From: [REDACTED]
Sent: [REDACTED]
To: Iqraa Malik
Subject: RE: 12 Chalet Road - FG/141/20/HH
Attachments: We sent you safe versions of your files; 20062 - 12 Chalet Road Ferring - 2.01C - bloc and loc Plan.pdf

RE: 12 Chalet Road - FG/141/20/HH

In terms of the description please amend to the following: **Proposed single storey extension to the front and rear. Proposed loft extension with south and east dormer. Replacement garage**

Location Plan - 1:1250 @ A1

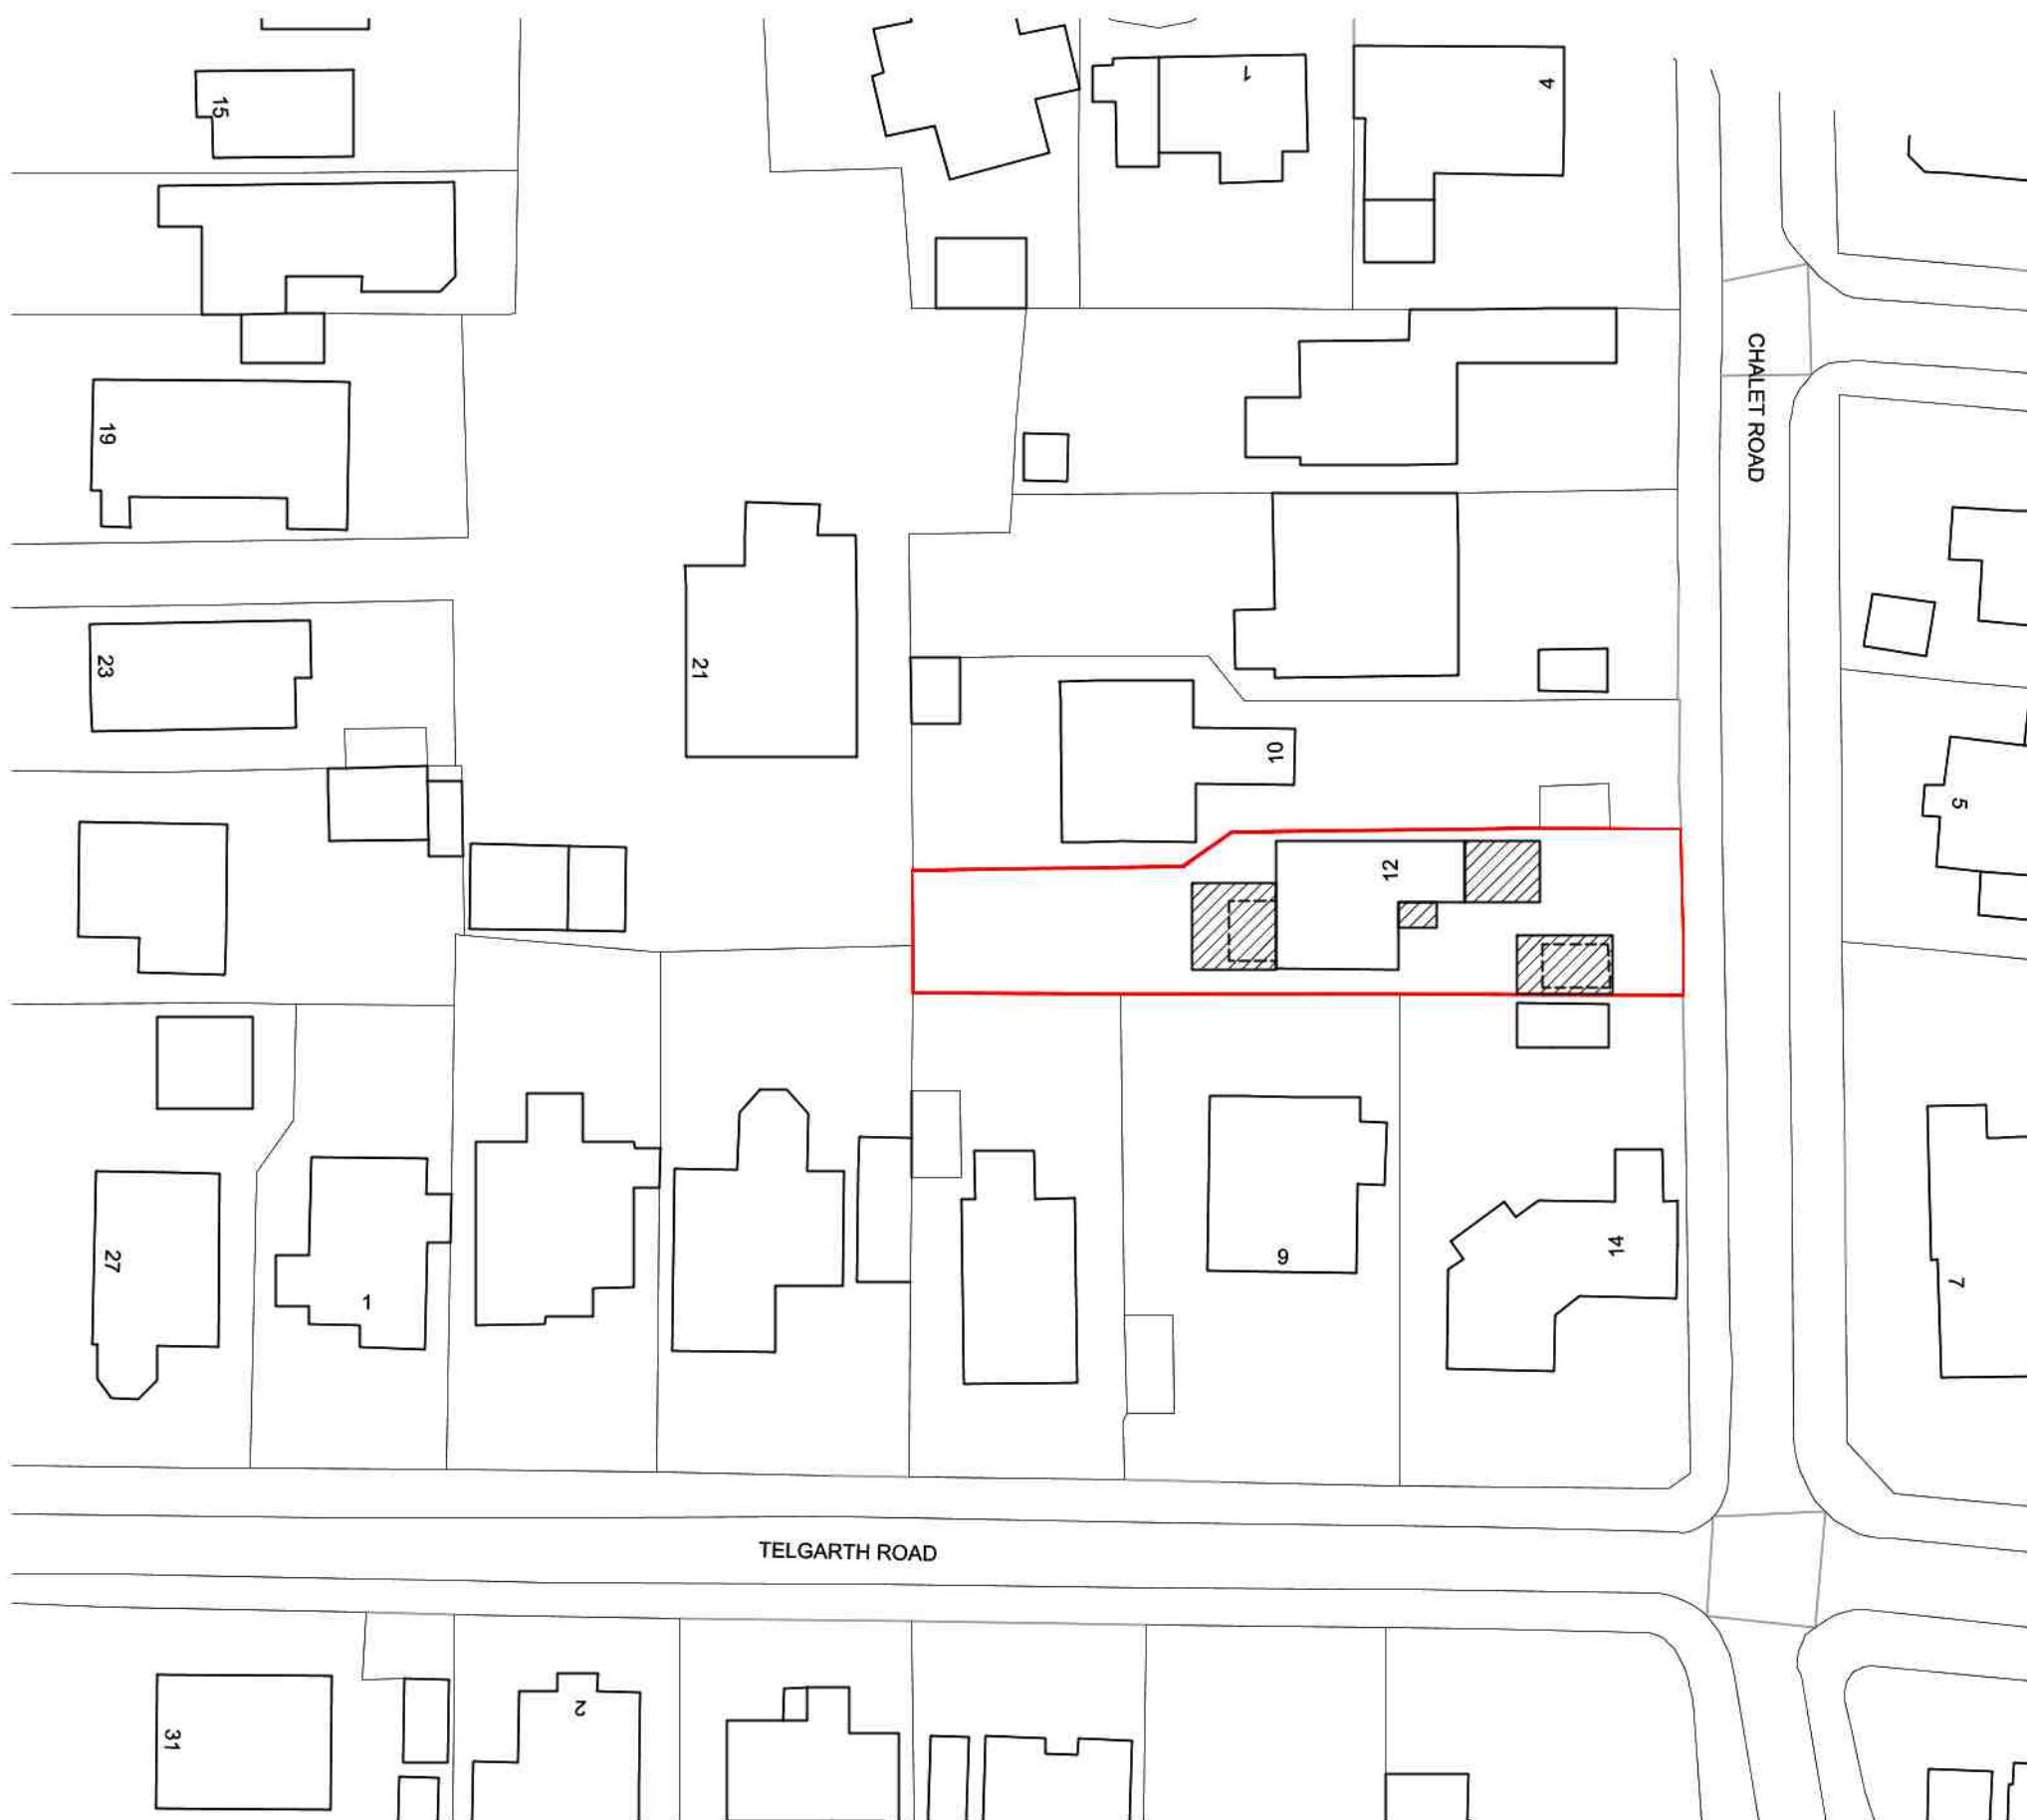
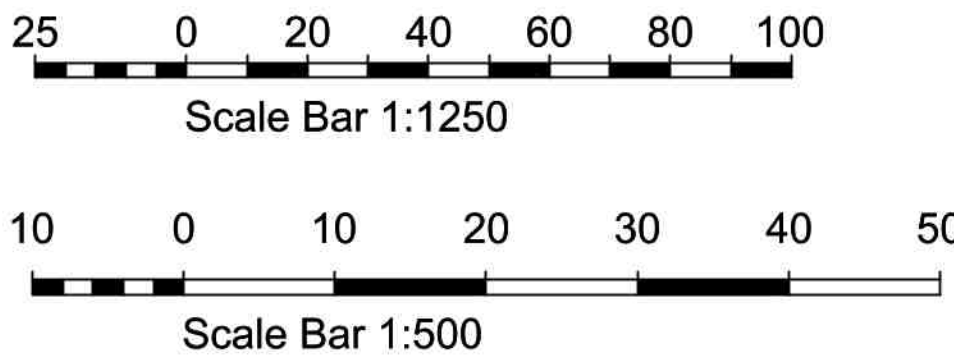
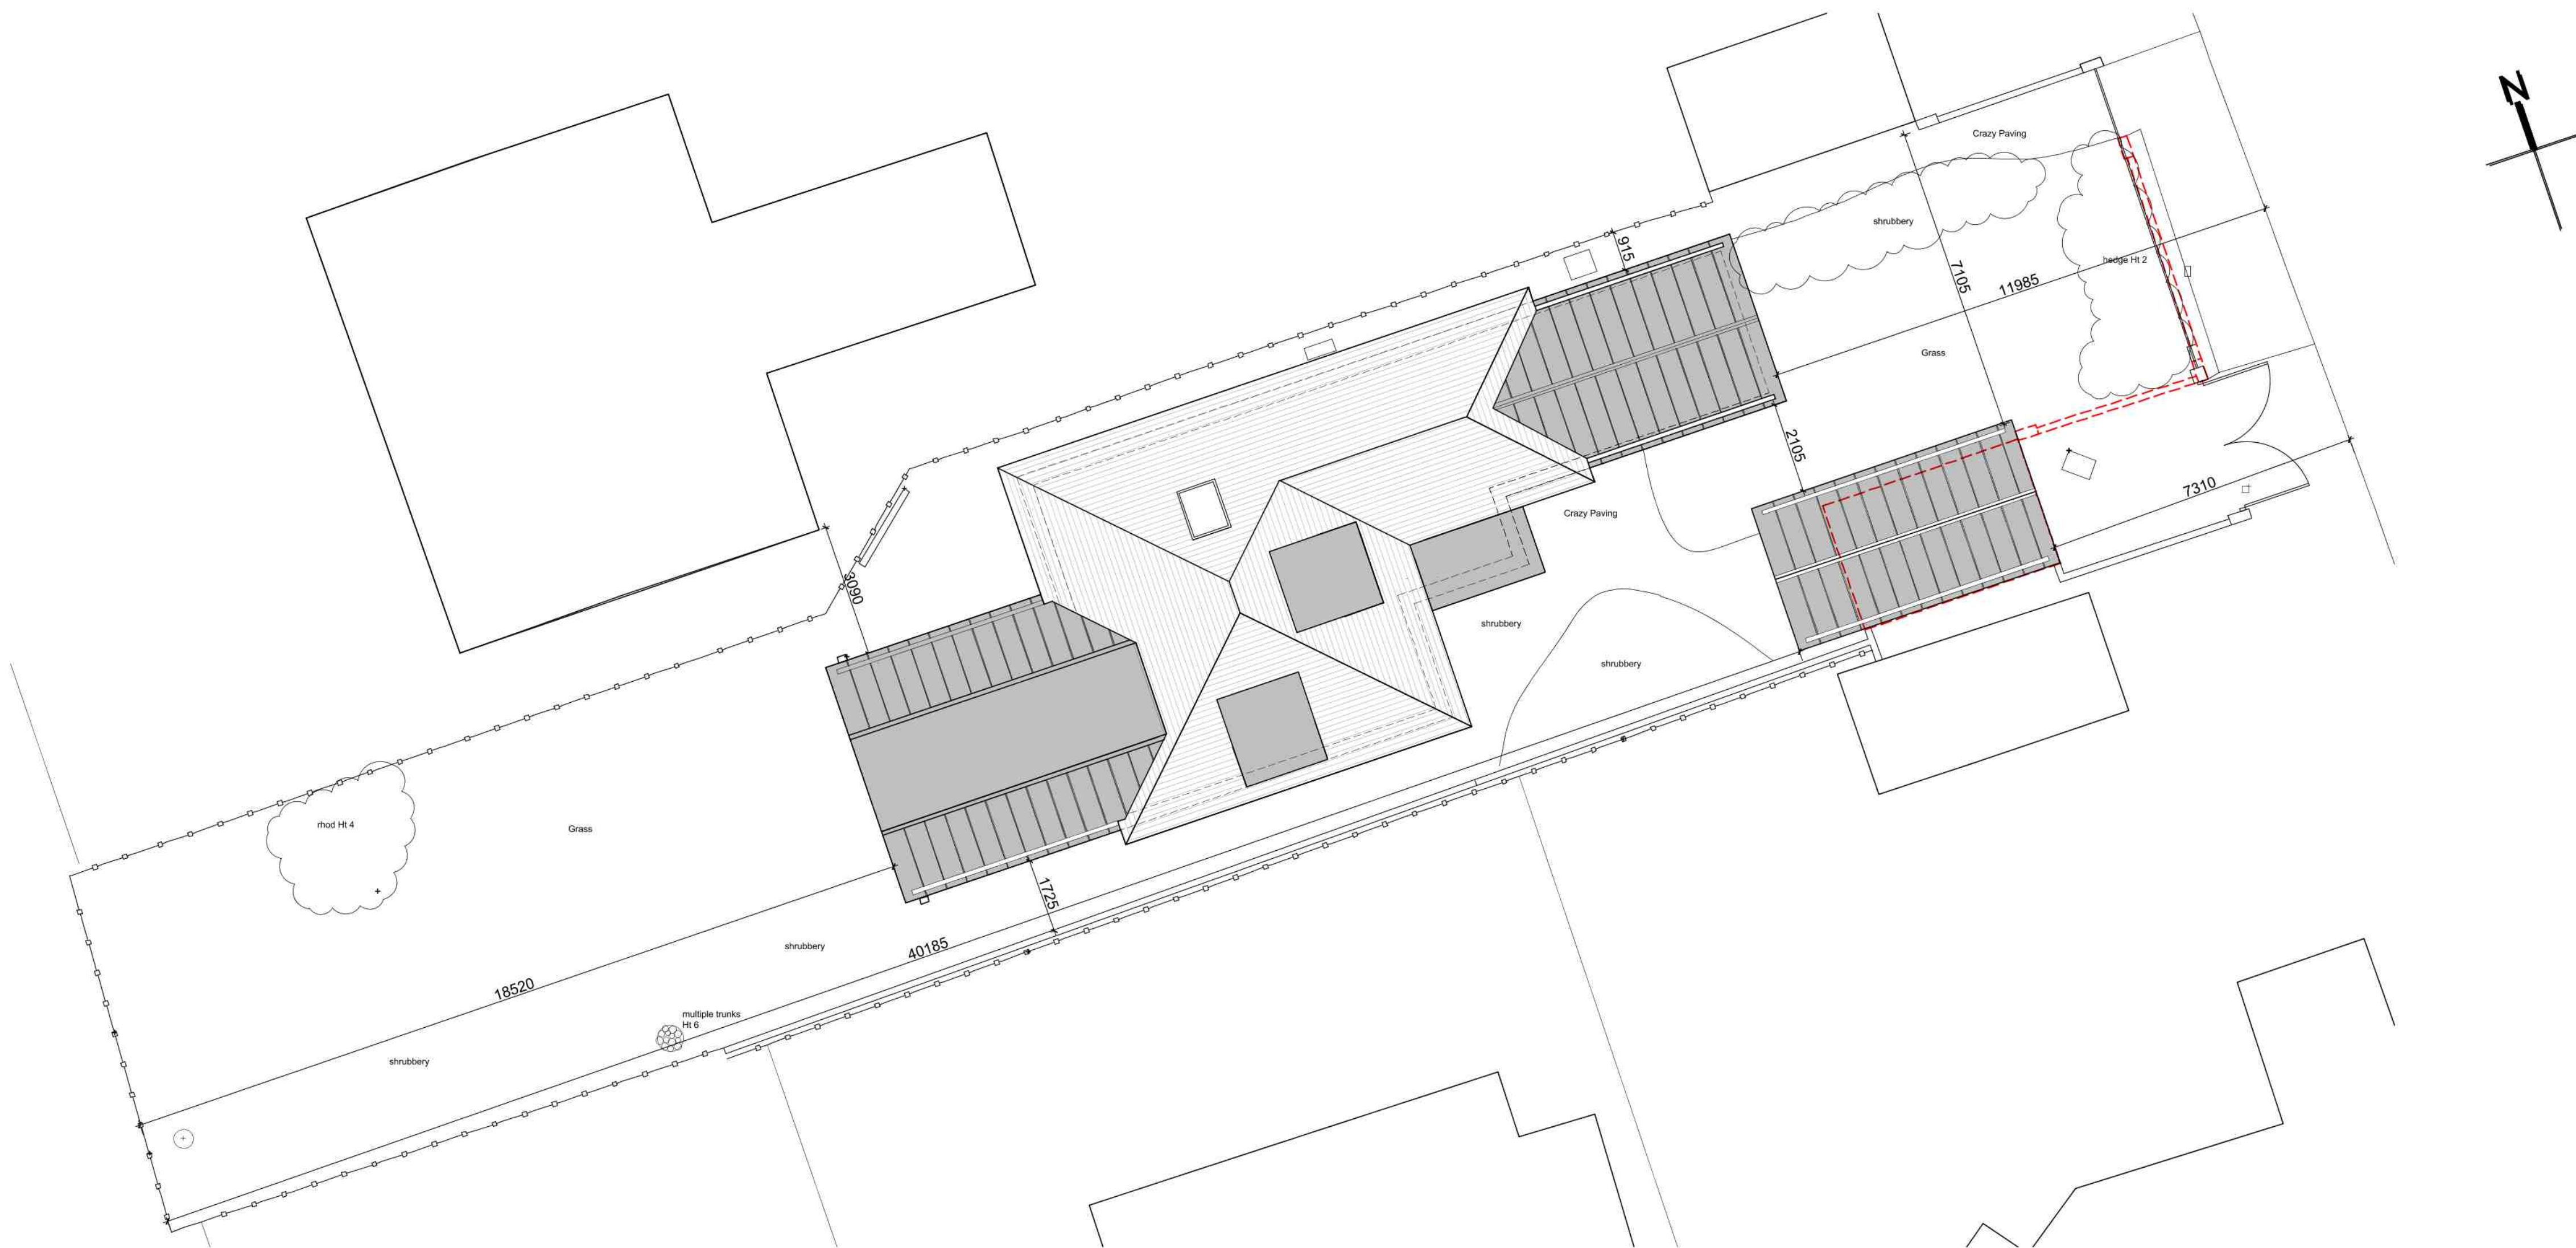
There seems to be a misunderstanding, the location plan only requires one solid red outline. There are over 5 outlines on the plan you have sent me. Along with this, as you will be altering the red outline on the location plan please also amend the red outline on the block plan to match this.

Your application is currently invalid as the location plan requires one solid red outline around the site address whereas you have more than one red outline on your location plan. Please amend.

I have amended the plan as per your request.

Please find attached revised drawing

In regards to your comment on the location plan, a redline is shown around the site.
